MEMORANDUM

TO: Jean Fraser, Planner
FROM: David Senus, P.E.
DATE: May 13, 2015
RE: 1342 Congress Street Neighborhood Center, Preliminary Level III Site Plan Application

Woodard & Curran has reviewed the Preliminary Level III Site Plan Application response to comments submittal for the for the proposed Neighborhood Center at 1342 Congress Street. The project involves the construction of a 19,300 SF building with associated site improvements that include a surface parking lot, stormwater management system, utilities, site lighting, and landscaping. The project will disturb approximately 85,000 SF and result in 12,500 SF of additional impervious area.

GRADING, DRAINAGE, AND EROSION CONTROL PLAN

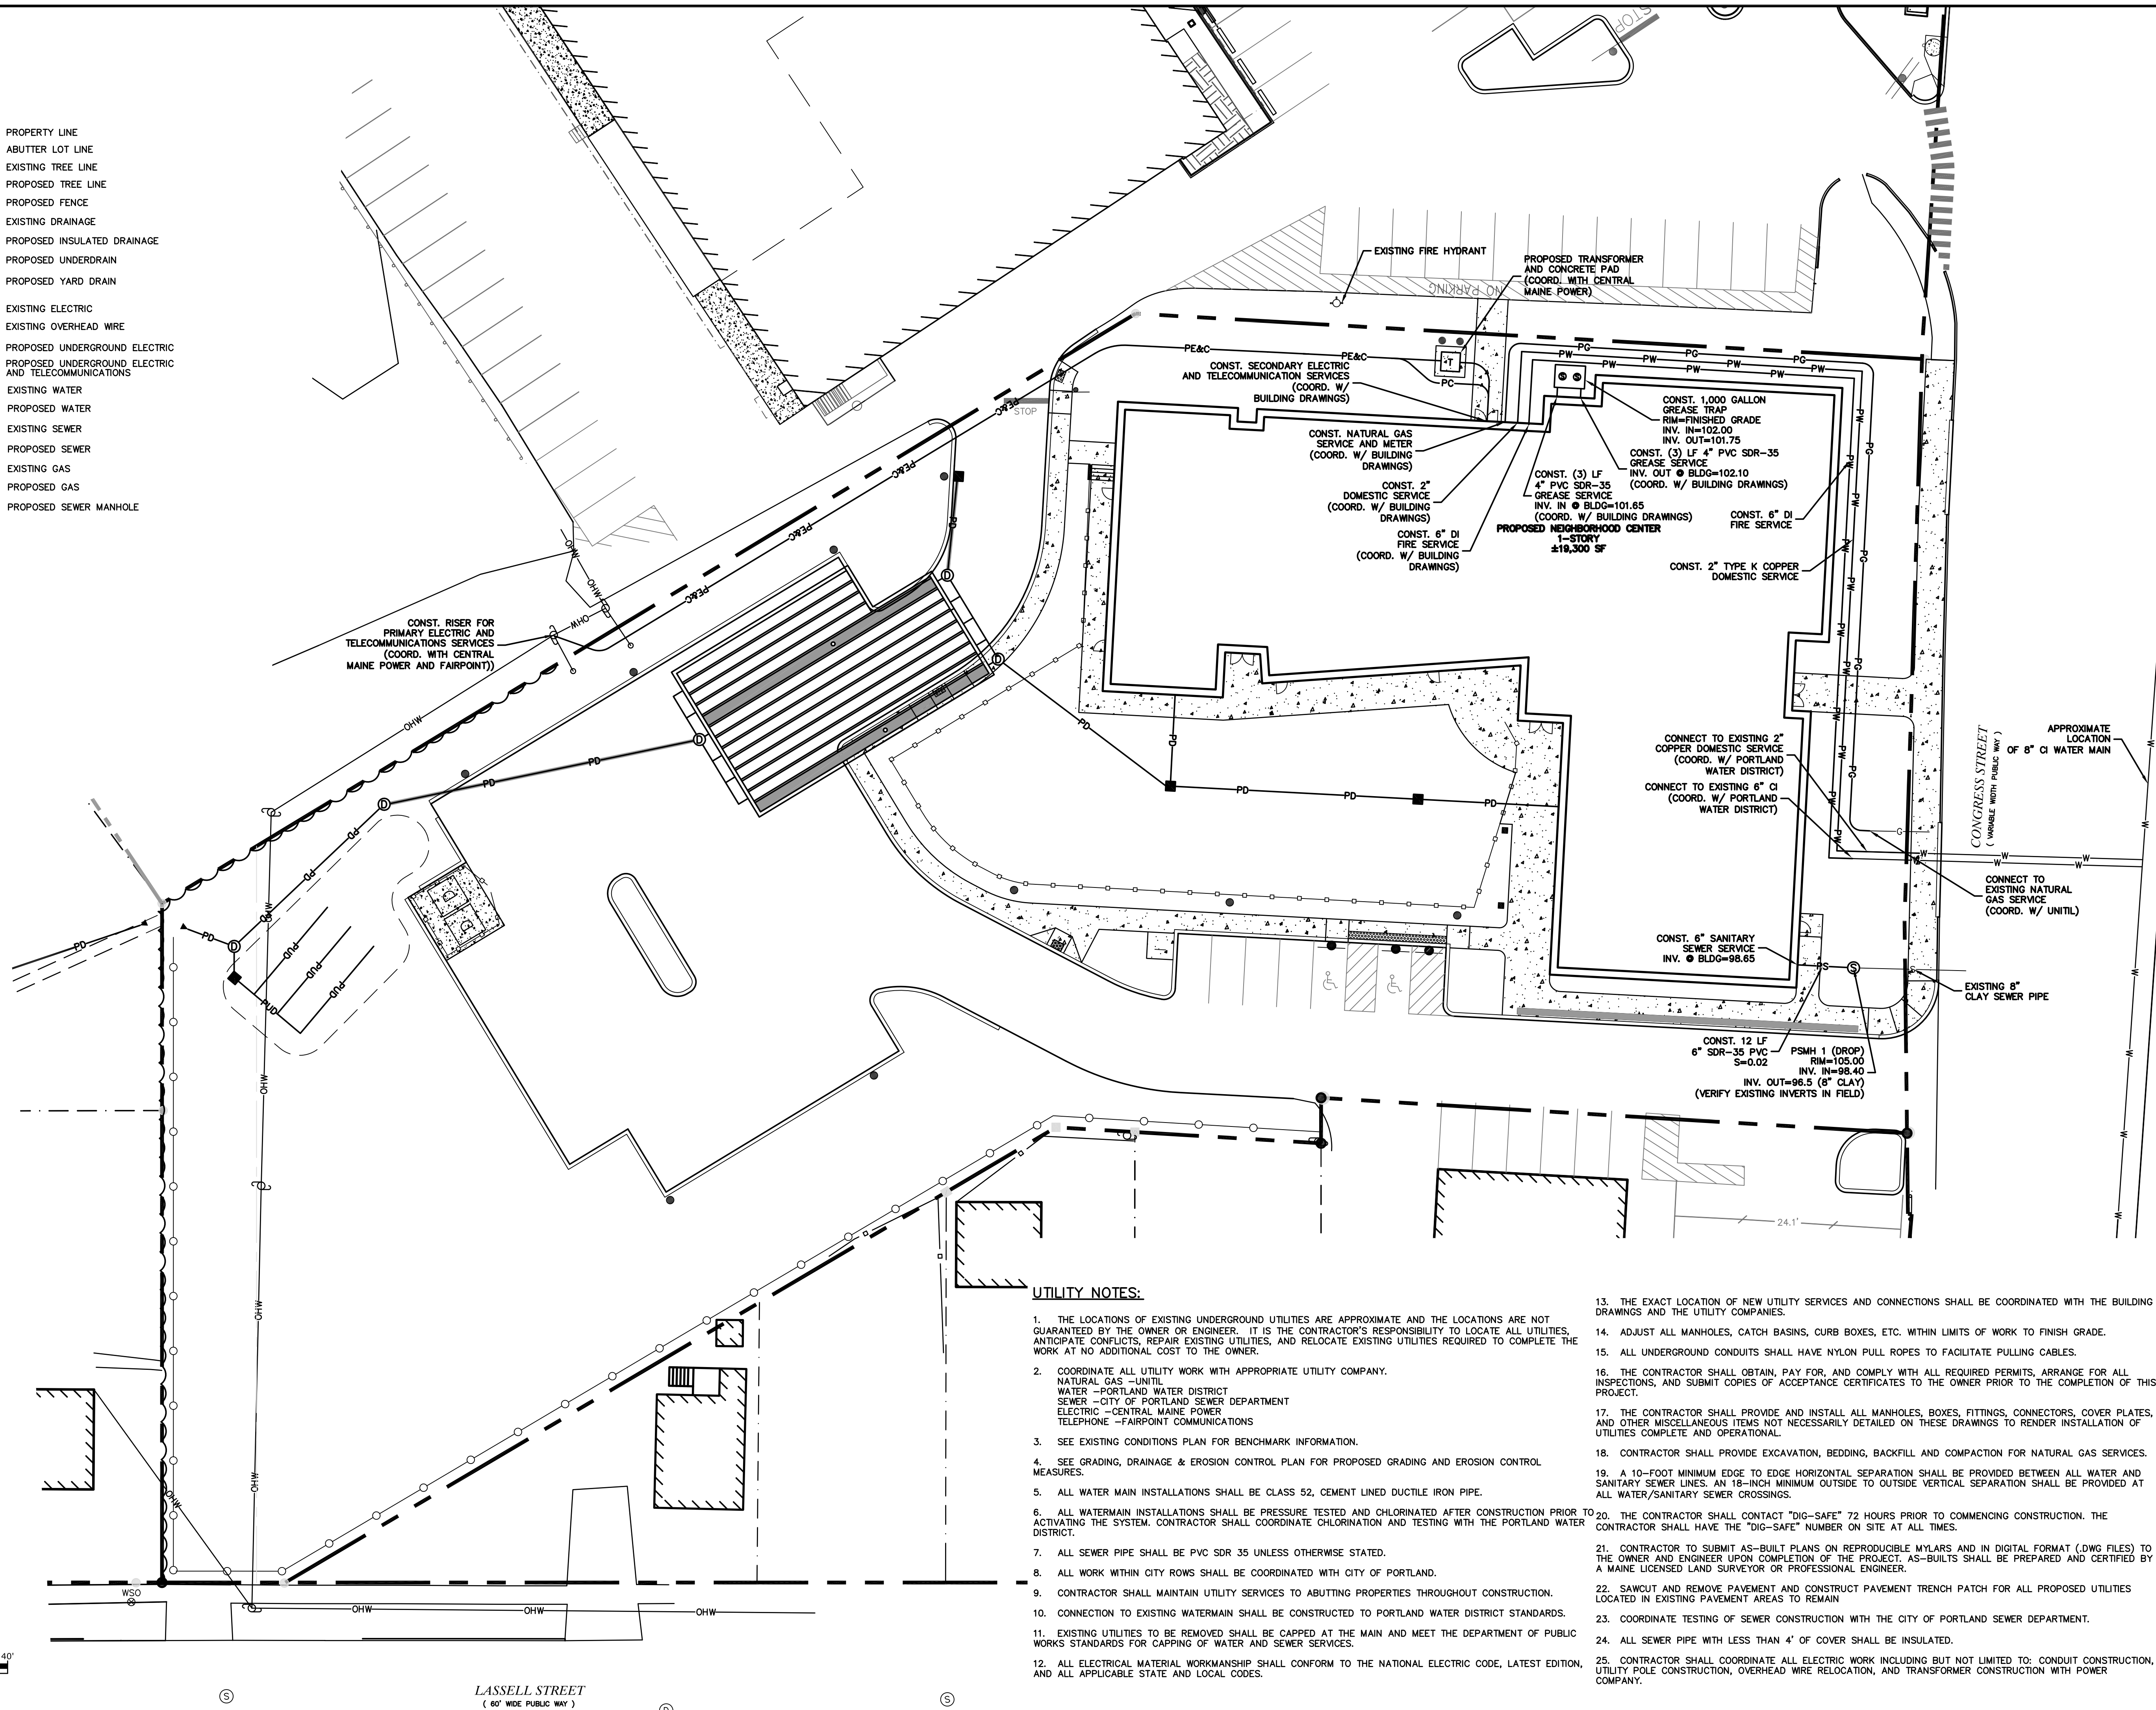
- 4) Sheet C-2b depicts snow storage along the east edge of the rear parking lot, adjacent to several residential properties. The grading plan (C-3) indicates that runoff from this area would potentially flow onto these properties. The Applicant should limit snow storage in this area and should revisit the

proposed grading to ensure that runoff from the project property is not directed onto these abutting residential lots.

Comment adequately addressed - The grading plan has been revised to provide for a shallow swale on the project property.

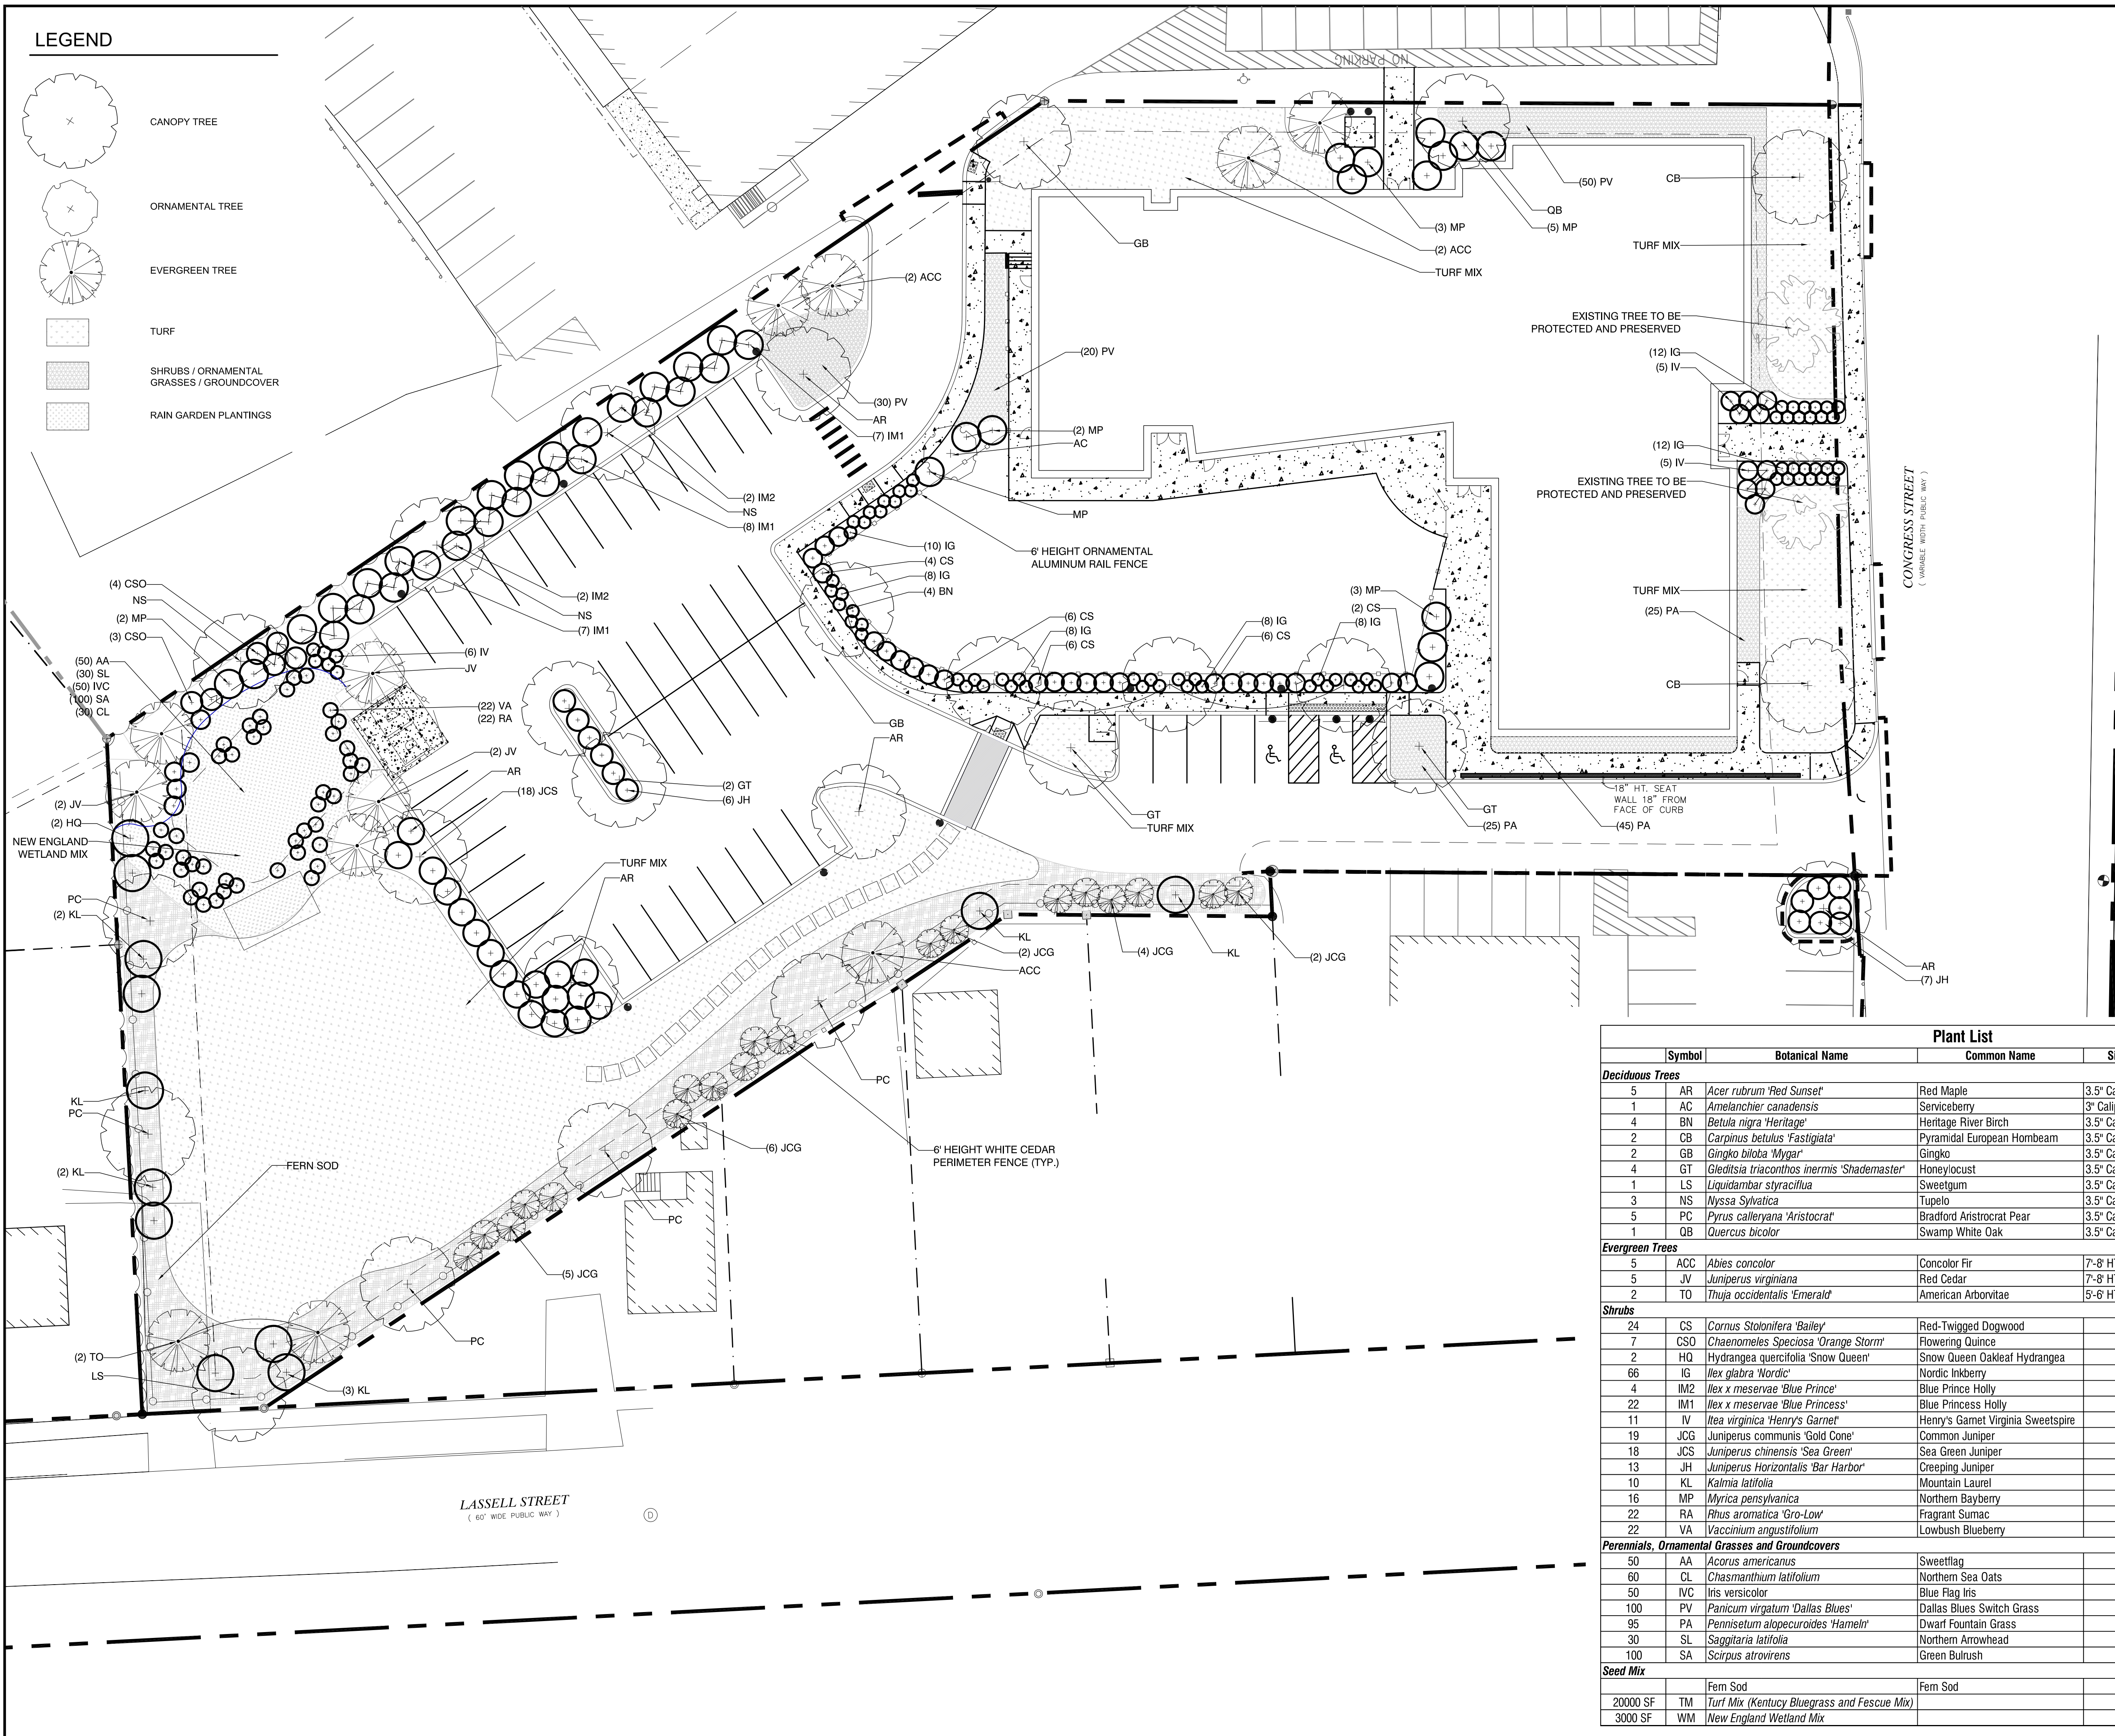
- 6) The proposed Underdrained Soil Filter Bed detail refers to a Rain Garden Planting Plan for proposed plantings; however, it does not appear that this plan has been provided at this time.

The Applicant has acknowledged that the Landscape Plan, Sheet L-1, will be updated to include an appropriate planting plan for the Underdrained Soil Filter with the Final Site Plan Submission.
